**From:**Anthony Newton  
**Sent:**Tue, 19 Jan 2021 21:21:51 +0000  
**To:**DCConsultees  
**Subject:**Peebles Civic Society response to 2/00024/FUL

**2/00024/FUL - Single Storey Extension to Dwellinghouse, 23 Edderston Road, Peebles**

Drawing Title:
Proposed Plans

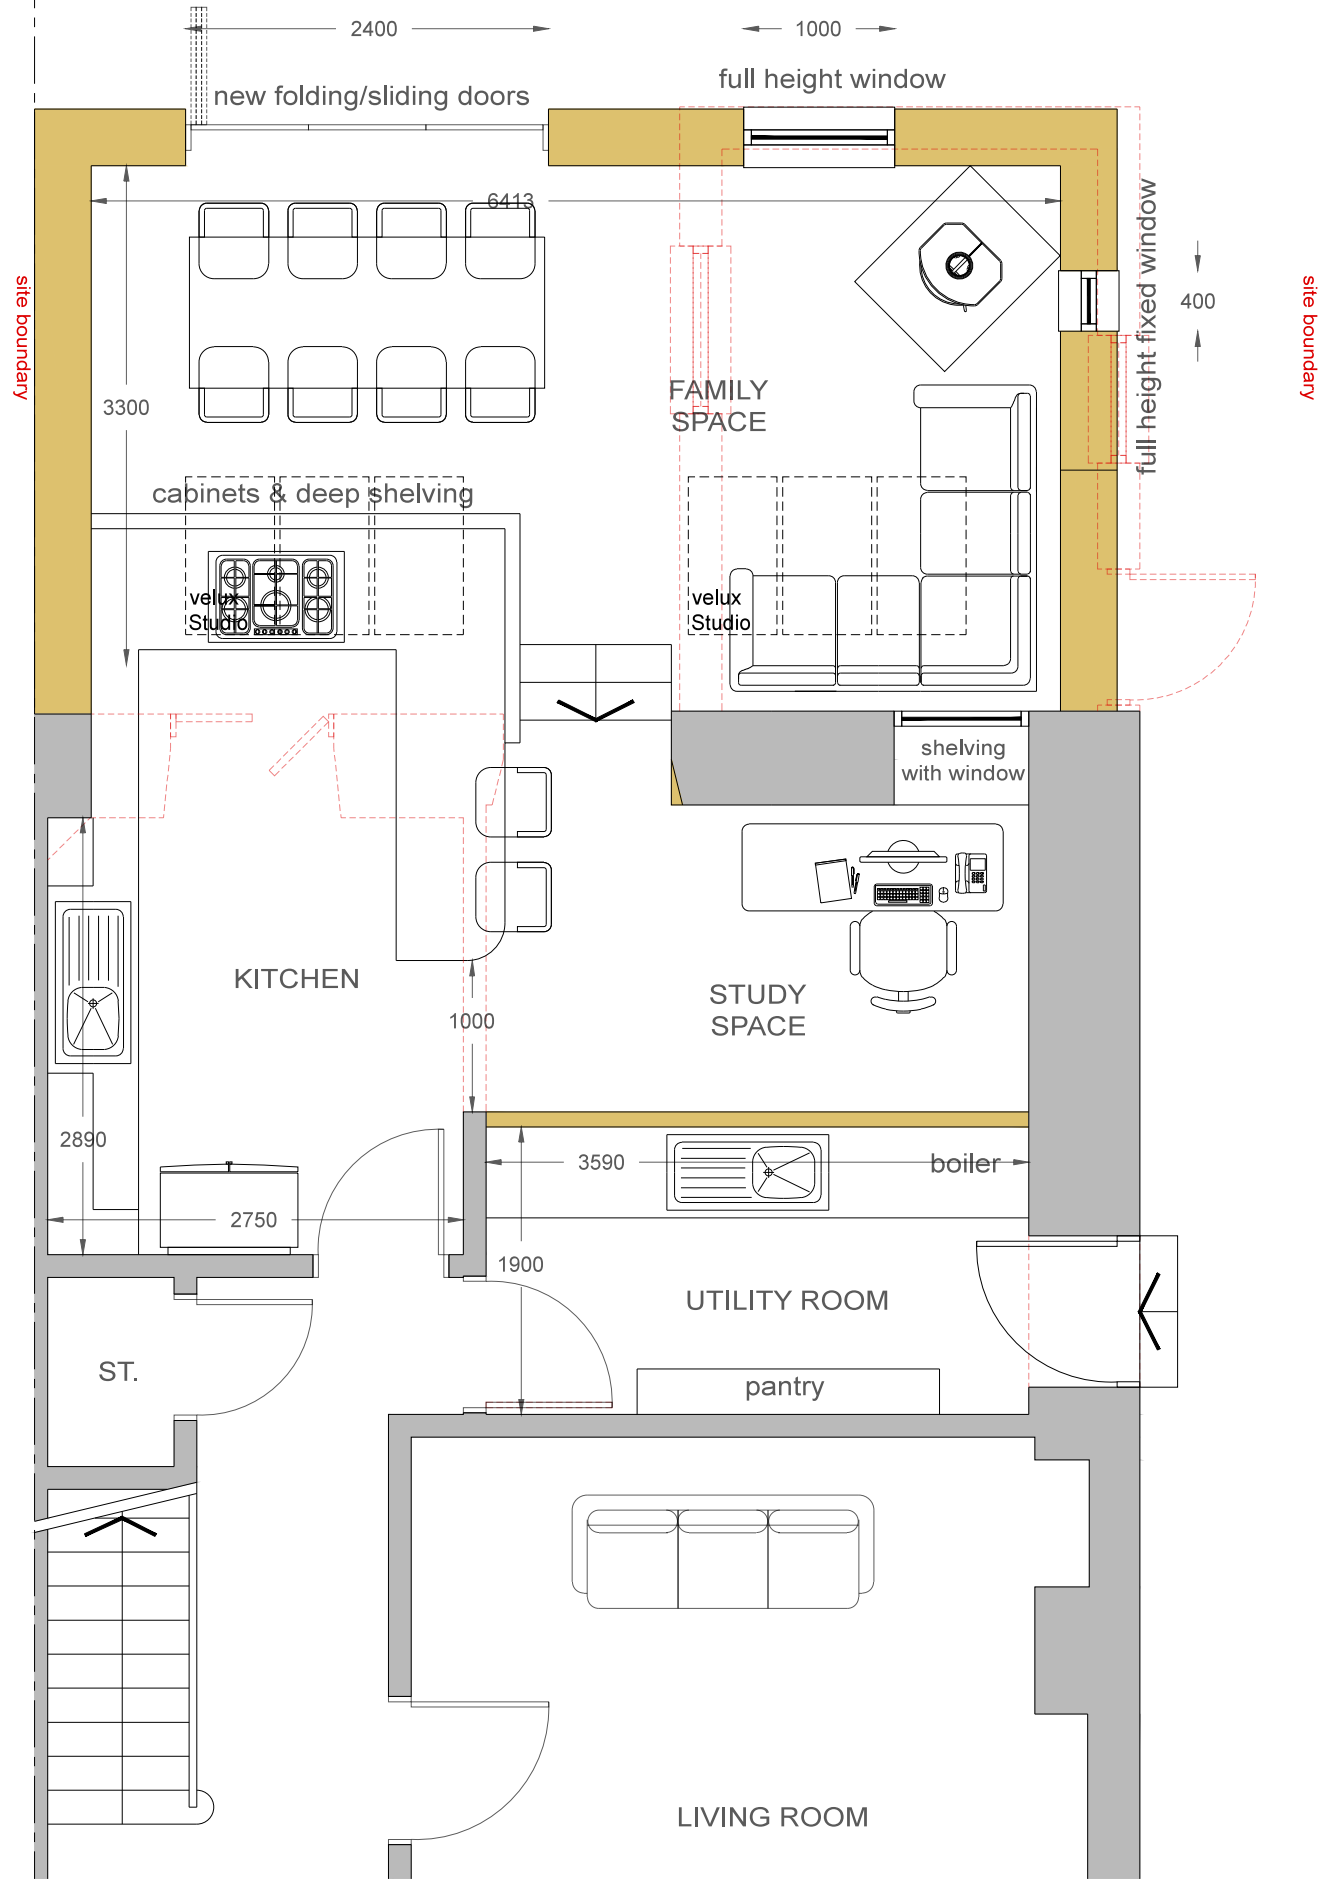
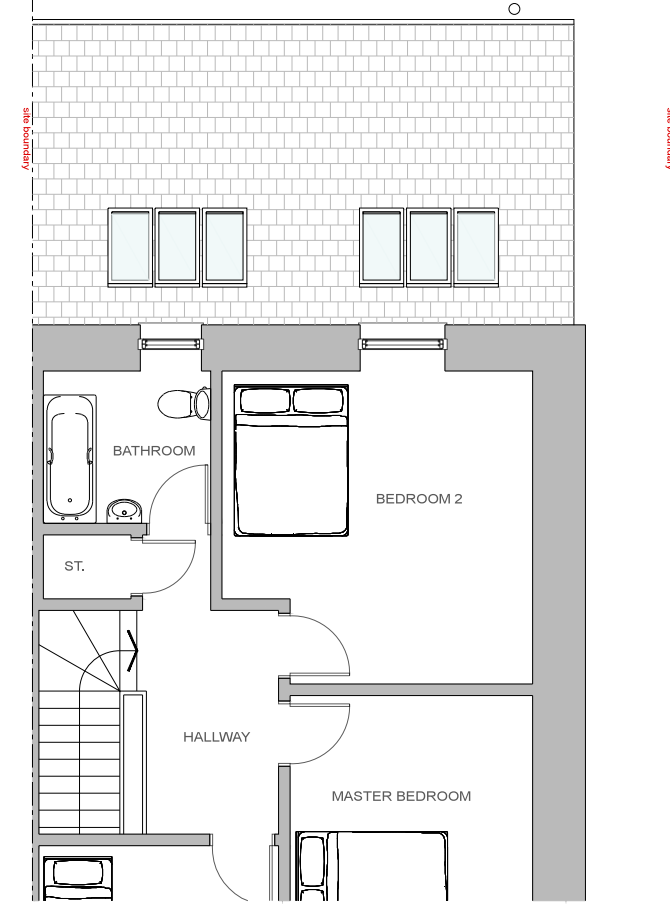
We have no objection in principal, but note that no details are provided to show how the proposed extension will join the current extension to the neighbouring property to the south. Details should be provided and approved by SBC.
